v6_PUDSP.pdf Markup Summary

RS-6000

SHEET NO.  
9  
 9 of 14 SHEETS  
 FILE NO.: PUDSP215

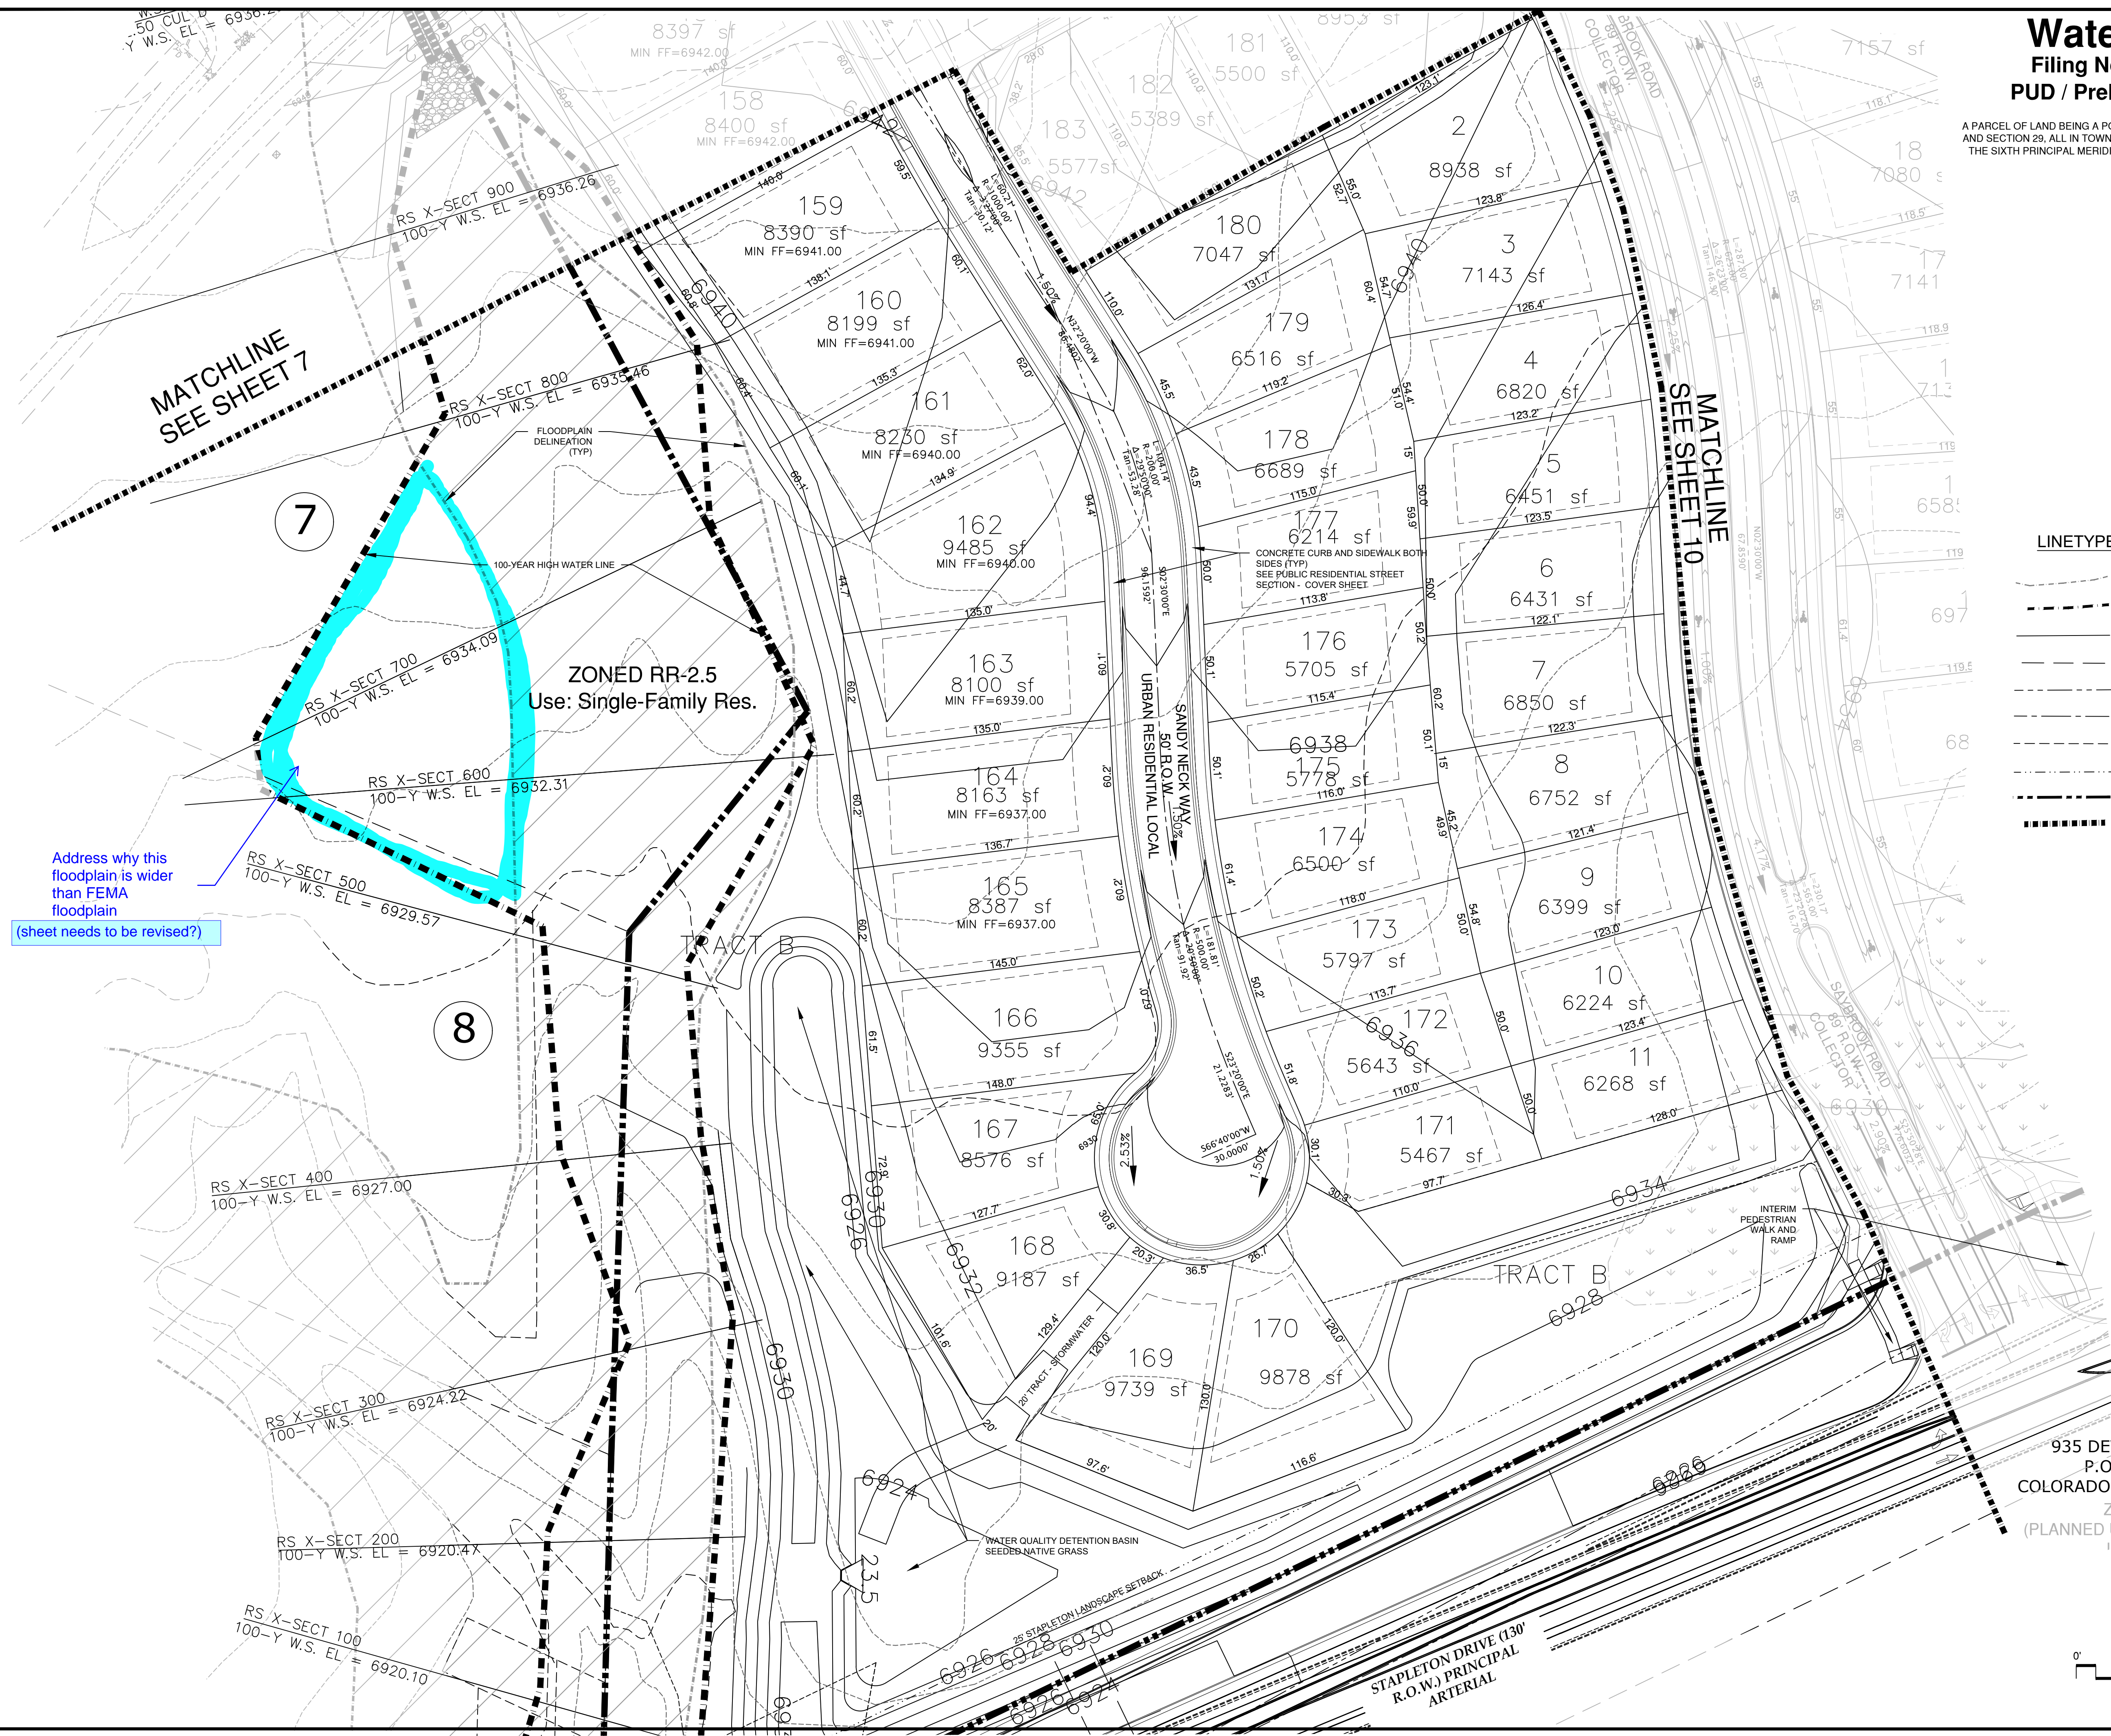
Address why this floodplain is wider than FEMA floodplain

SHEET NO.  
**12**  
12 OF 14 SHEETS  
FILE NO.  
PUDSP215

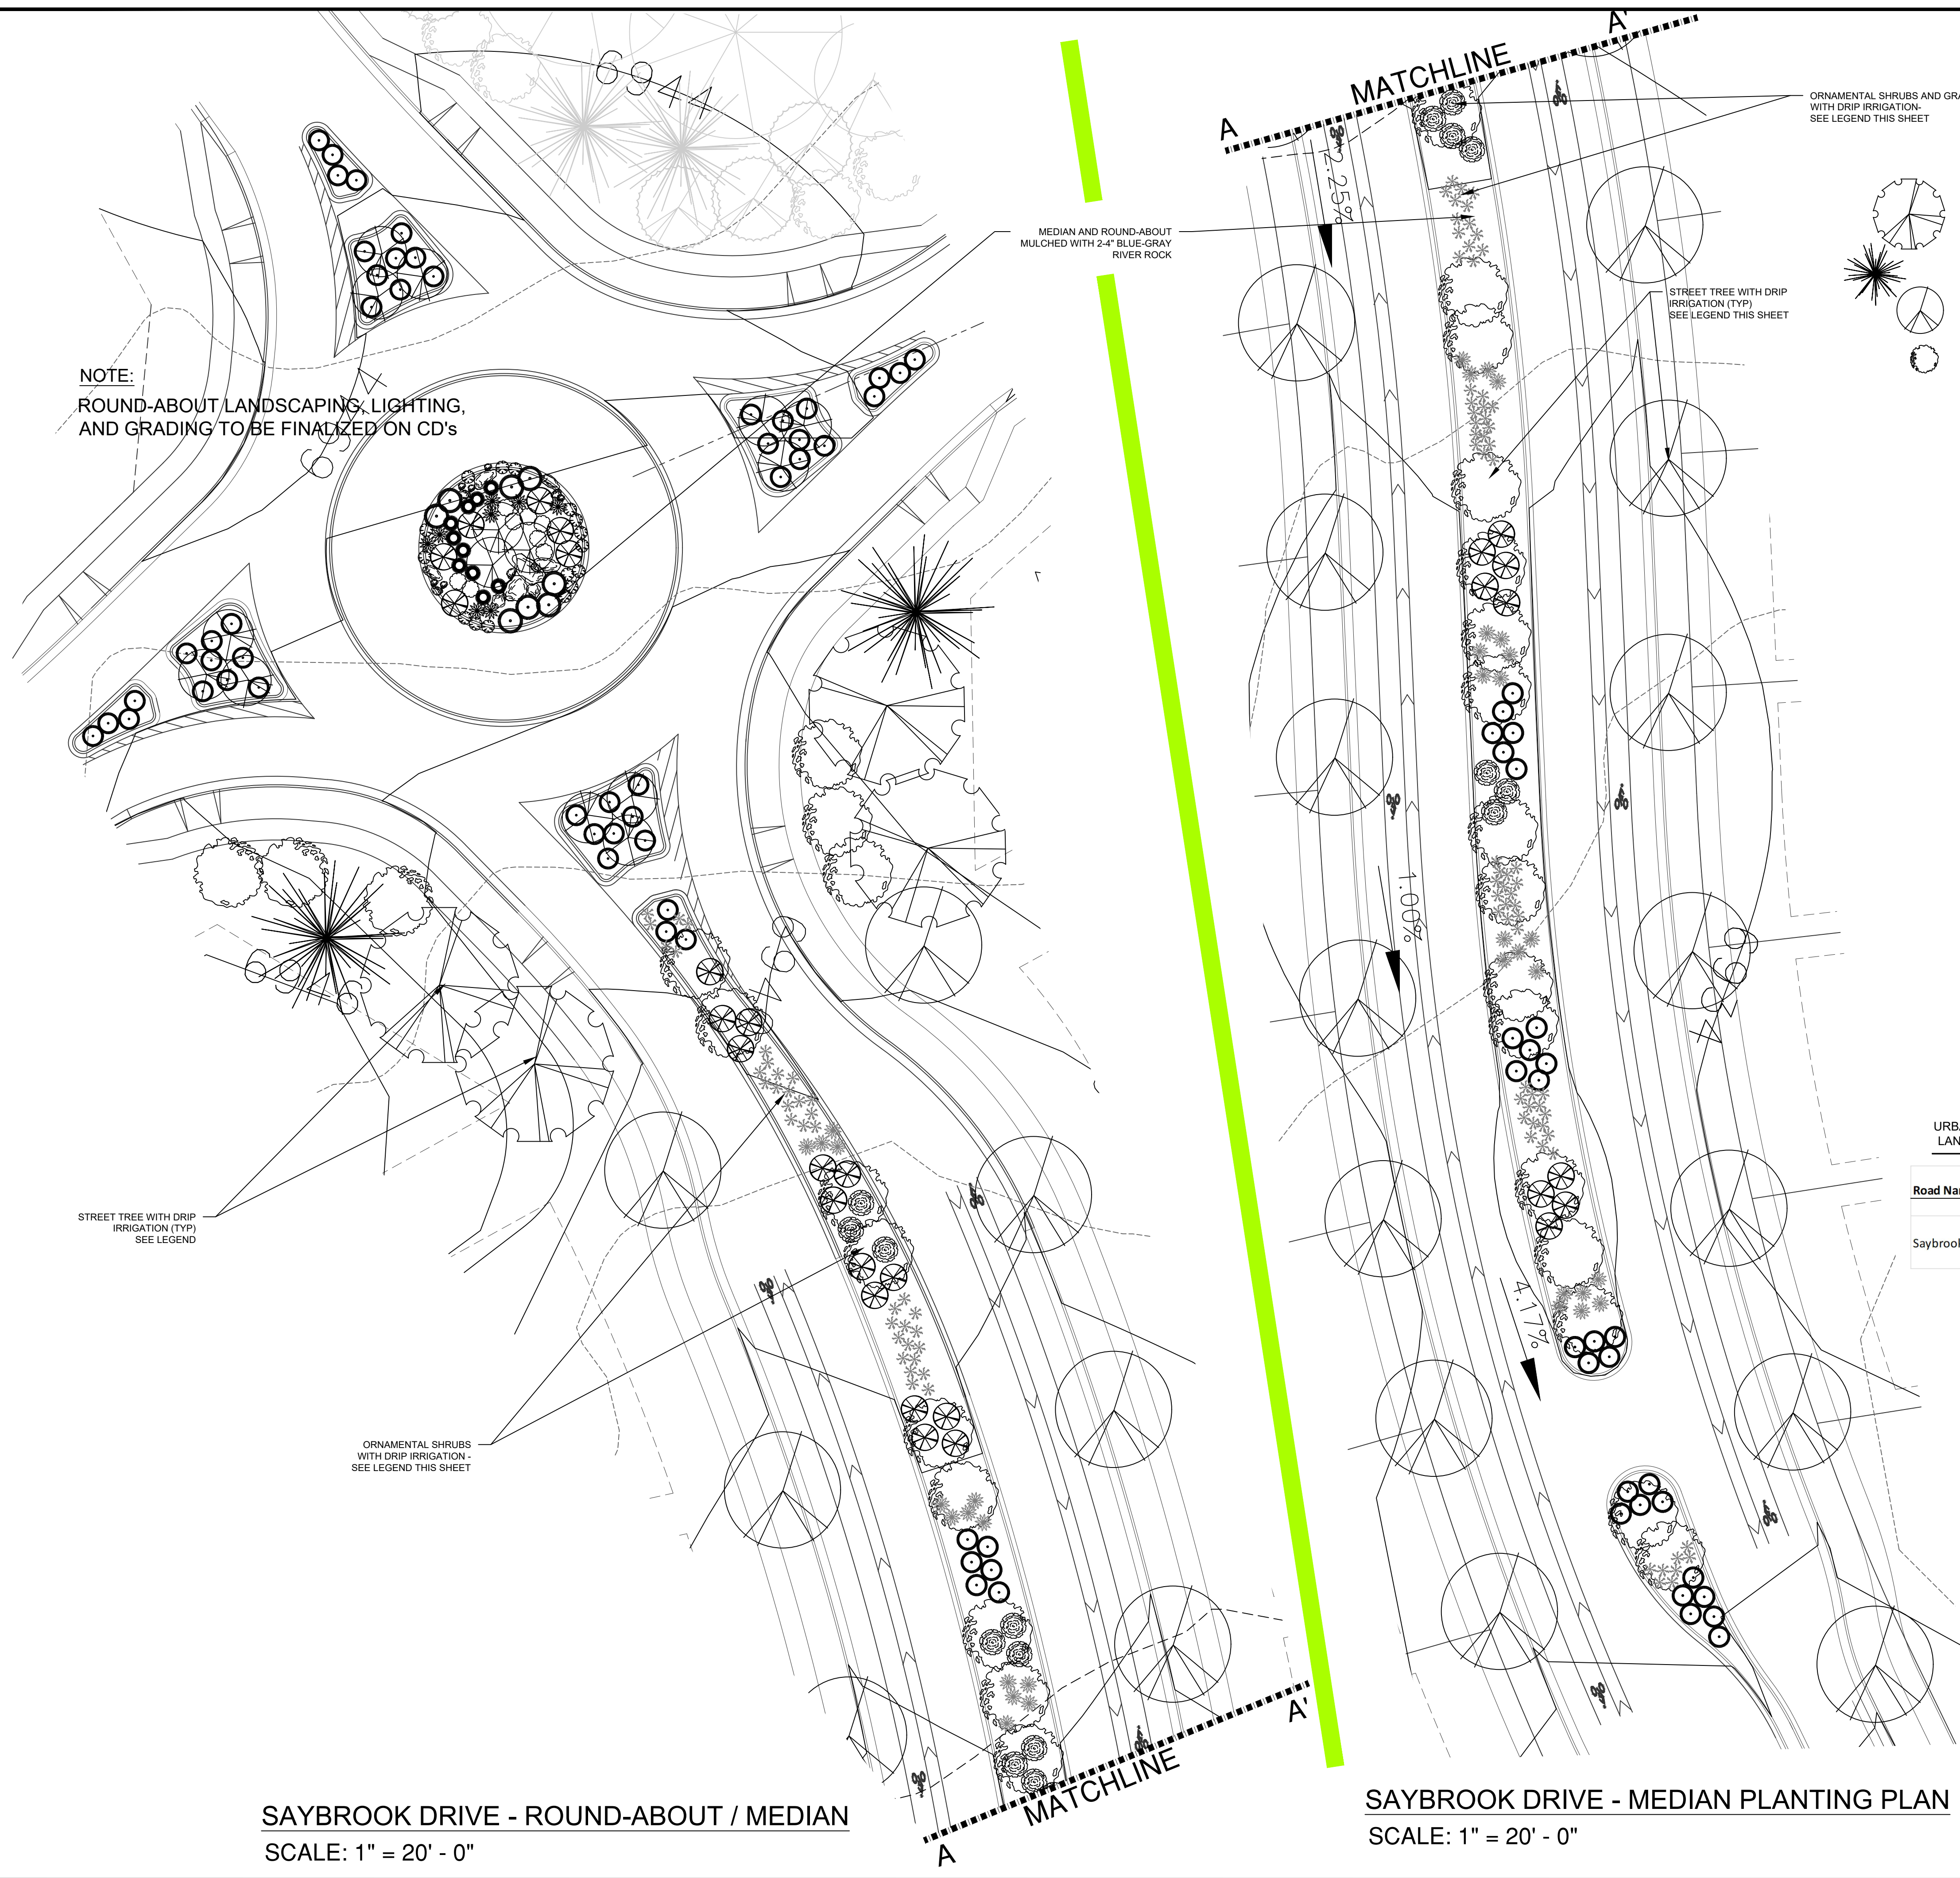
Adjust text
